Consultation Response from: KC Environmental Health (Pollution & Noise Control)

2025/91415 - Shelley Lodge, 2, Box Ings Lane, Shelley, Huddersfield, HD8 0SU

Discharge of details reserved by condition 6 (Phase II Report) on previous permission 2021/92355 for alterations and extension to existing stables to create dwelling

Condition 6 – Phase II Report

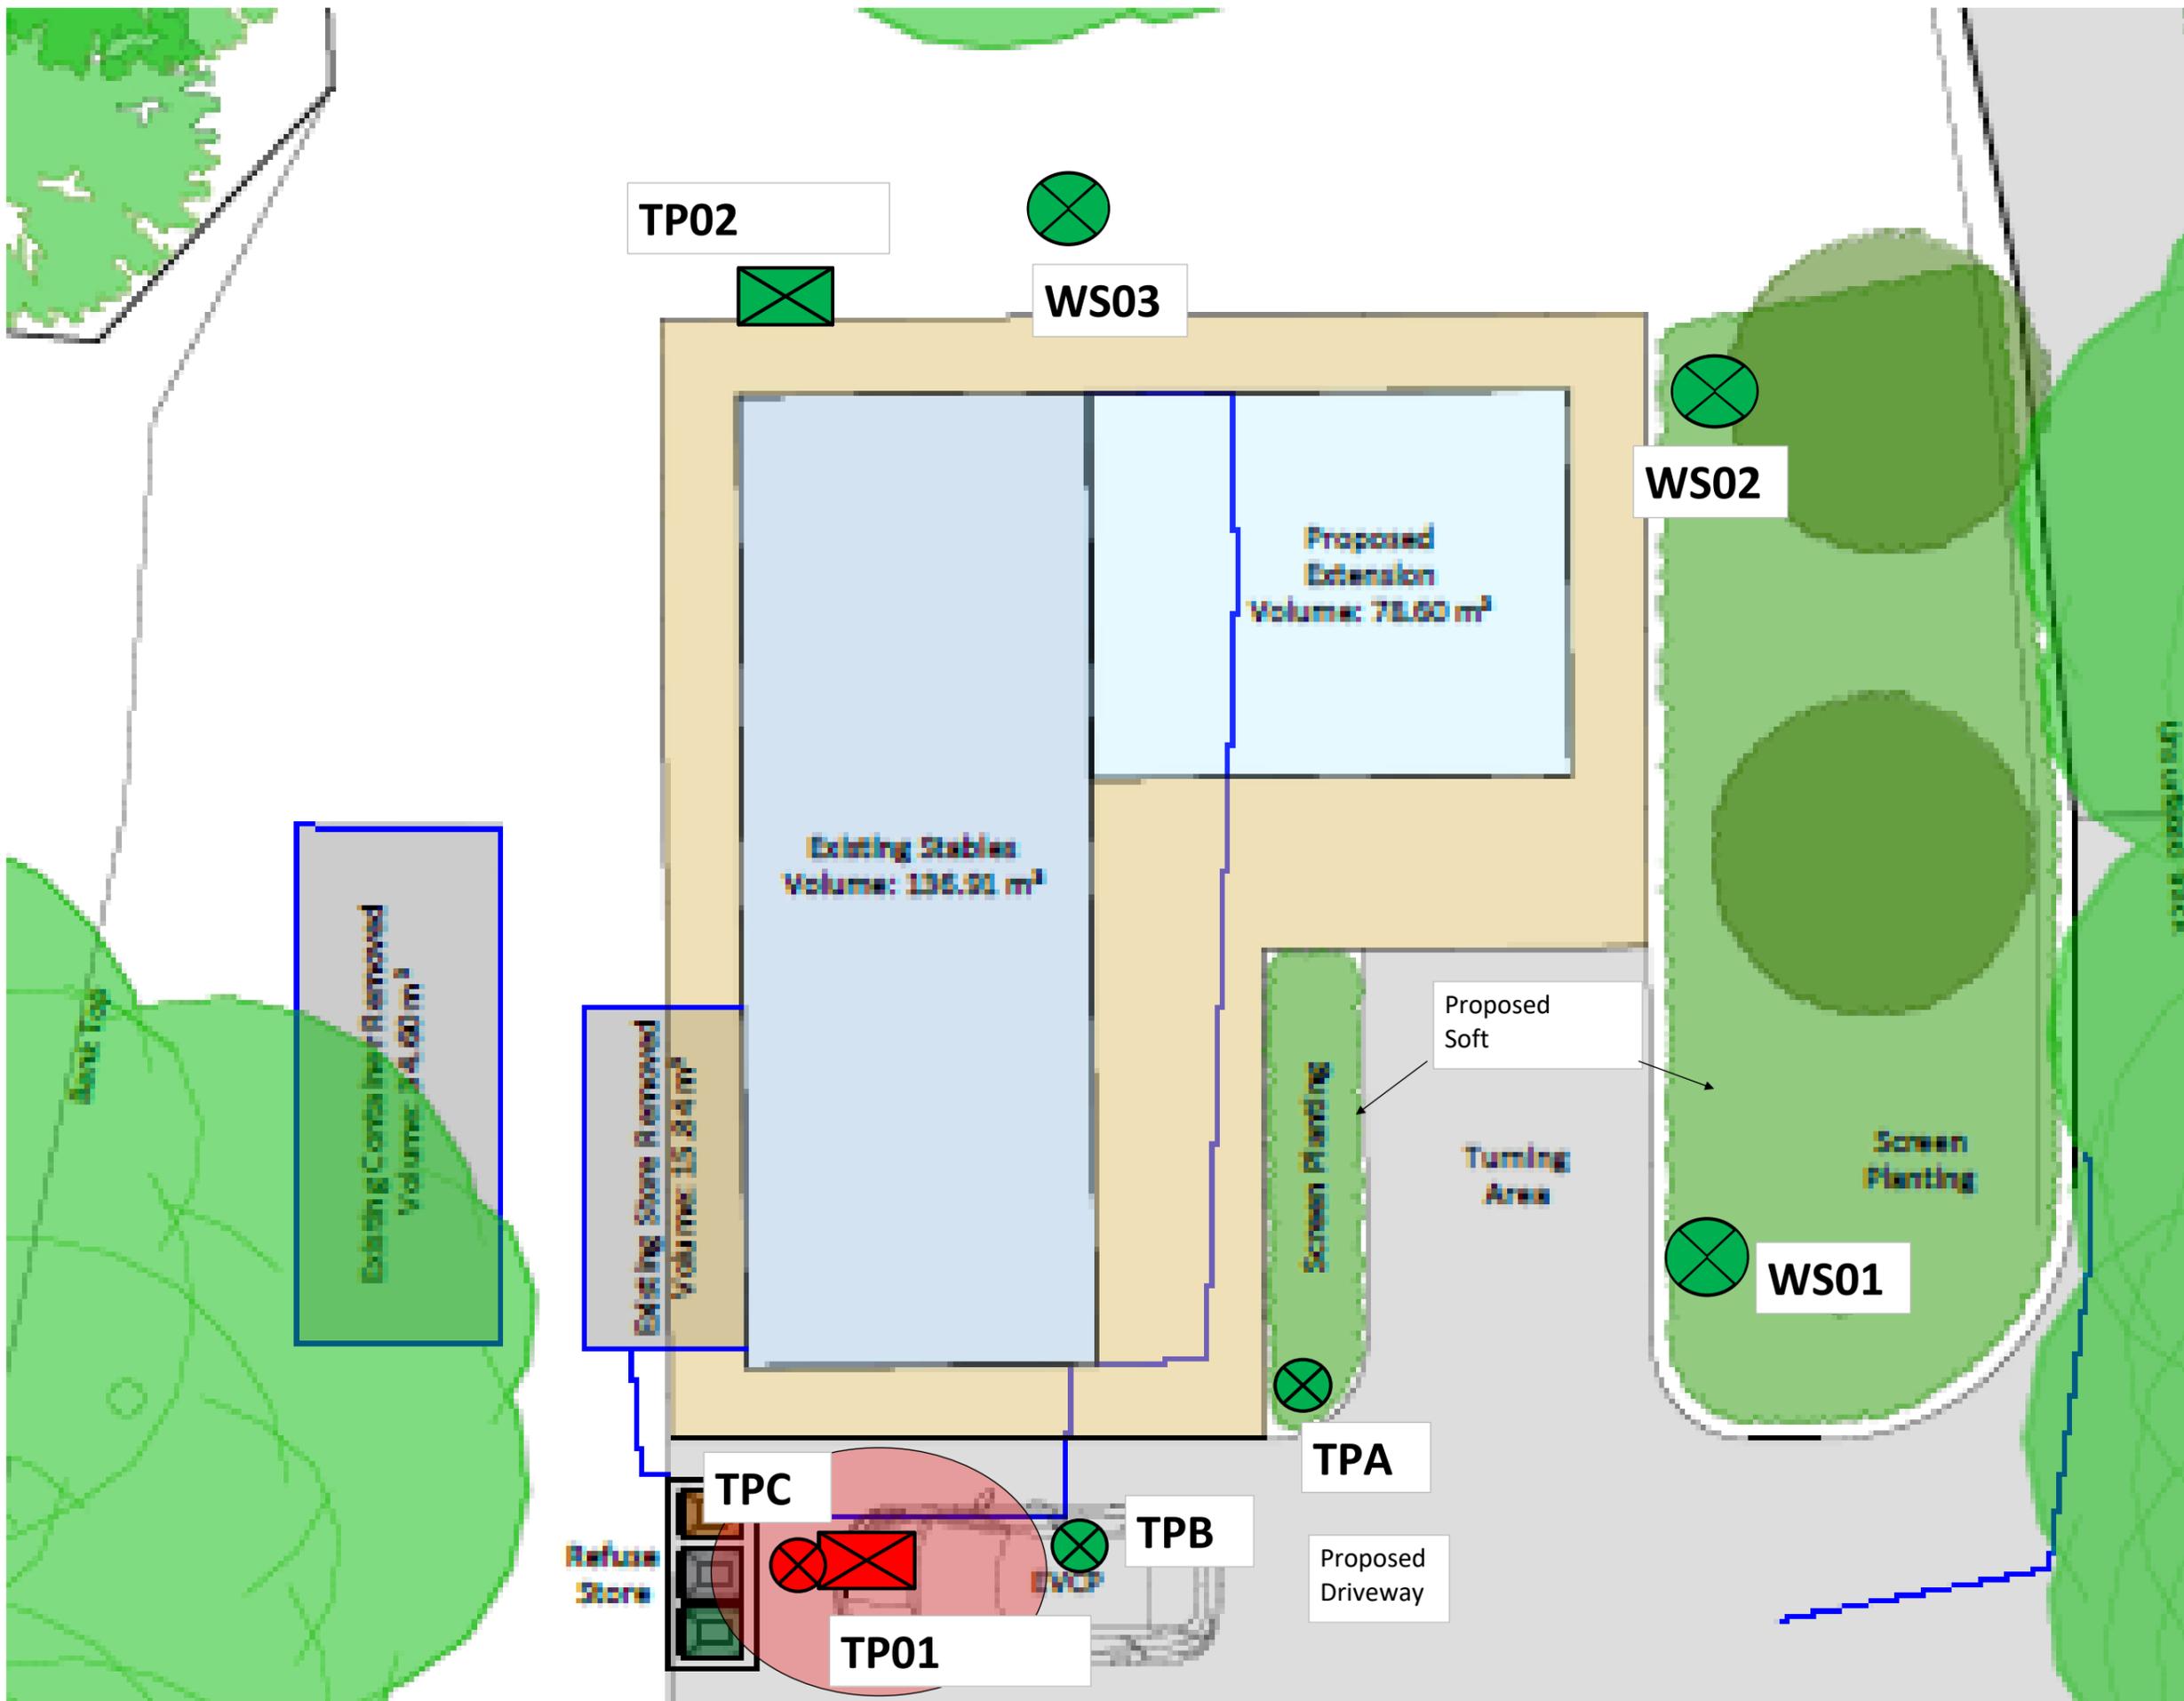
Additional intrusive works included three trial pits (TPA - TPC) to further investigate the extent of previously identified contamination. Elevated concentrations of PAHs were detected within ash-containing made ground beneath the driveway, whereas soils within the soft landscaped areas were suitable for the intended residential use. RGS conclude that the impacted material beneath the driveway presents no risk as it remains sealed beneath hardstanding.

While this conclusion appears reasonable, the extent and volume of the impacted made ground have not been clearly defined. It is unclear whether the full lateral and vertical extent of the ash-containing material has been delineated, or whether all impacted material has been fully encapsulated beneath hard standing. These aspects require confirmation to demonstrate that the identified source–pathway–receptor linkage has been effectively broken.

Until these matters are fully addressed, we recommend that Condition 6 remain in place and that further consultation with Environmental Health be undertaken once clarification is provided.
